Your Ref: OWPC14383
Our Ref: A/87/17/HH 08-05-2017
Please ask for:
Mark Jones

Single storey rear extension under pitched roof
The Old Cottage Station Road Angmering

Thank you for your internet representation made on 27th June 2017 which has been recorded as '**an objection**' with the comments as follows:

PROPOSED FLOOR PLANS 1:50

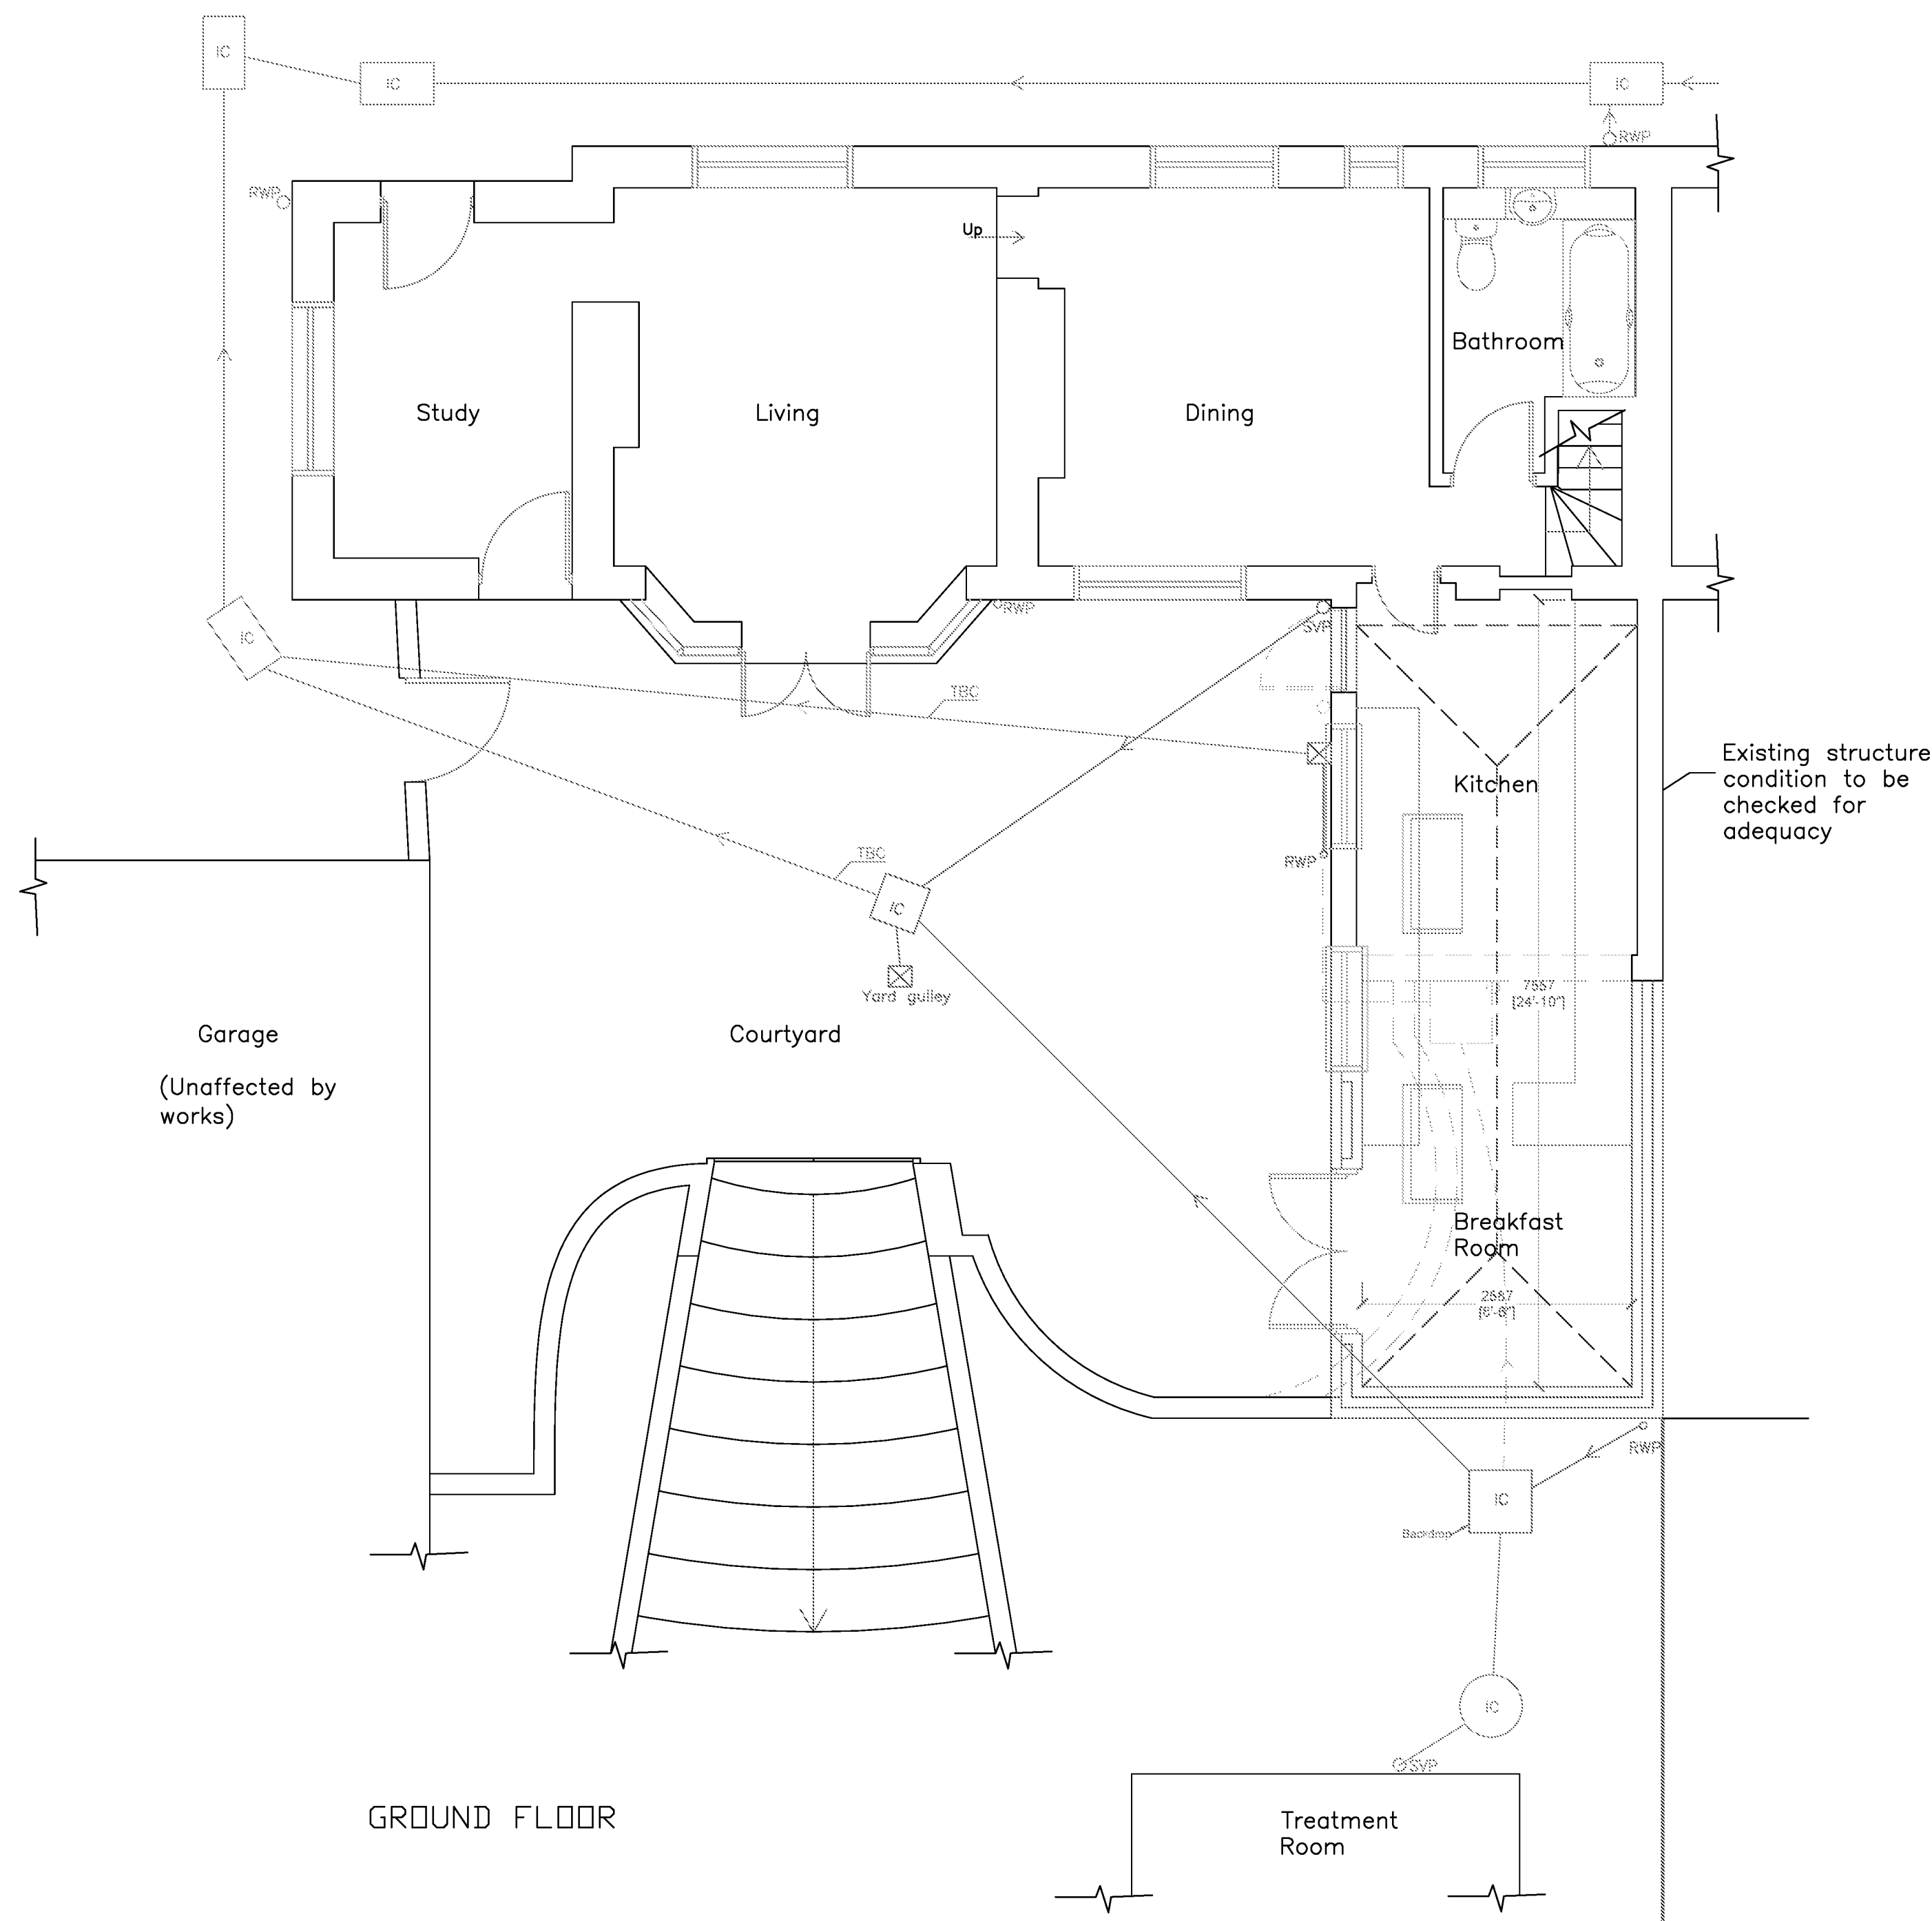
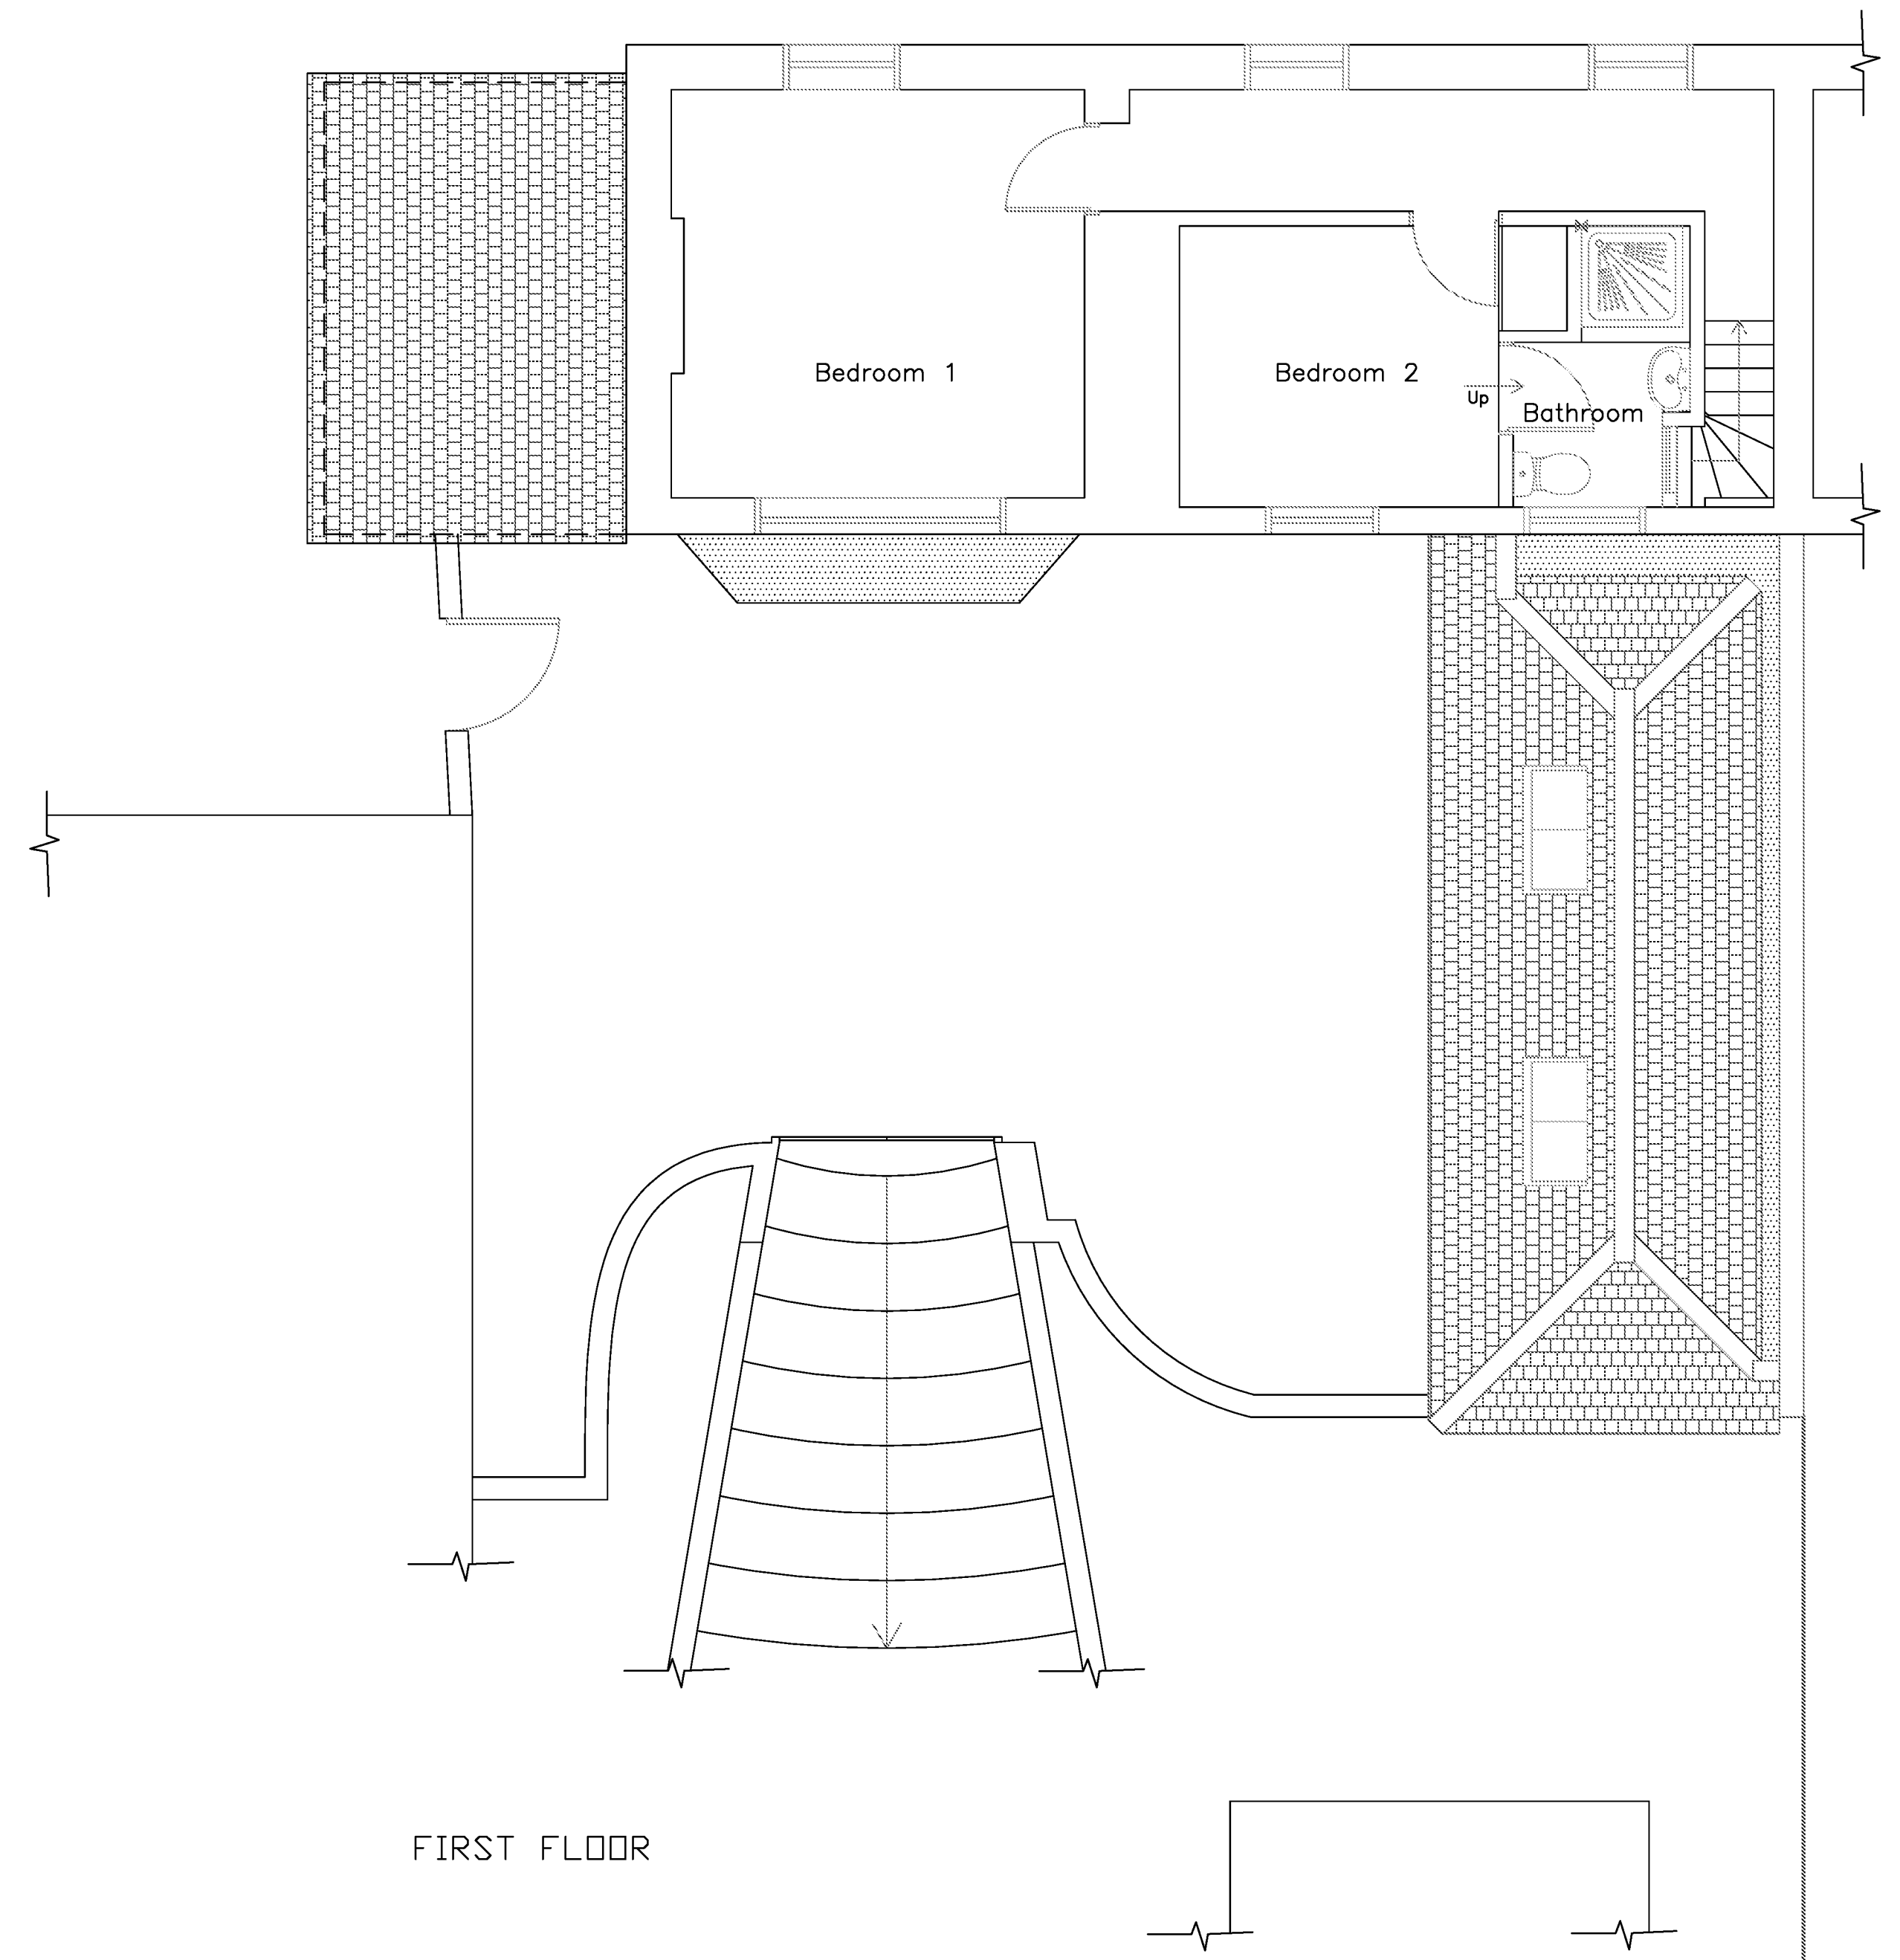
This plan appears to infringe on land currently occupied by the neighbouring property, The Old Mill House. The proposed outer wall of the breakfast room continuing the line of the existing outer wall of the kitchen would require the demolition of the existing boundary fence and the digging up of the hedge, garden and mature shrubbery of the Old Mill House. This land has been used by the owner of the Old Mill House for 38 years as part of their own fenced in garden, regardless of any line which might (?) be officially drawn on the Deeds. This gives right of possession to the Old Mill House not the Old Cottage. There needs to be a thorough investigation of the boundary question before any work is permitted, especially as the owner has recently moved to a Care Home and cannot monitor this on a daily basis.
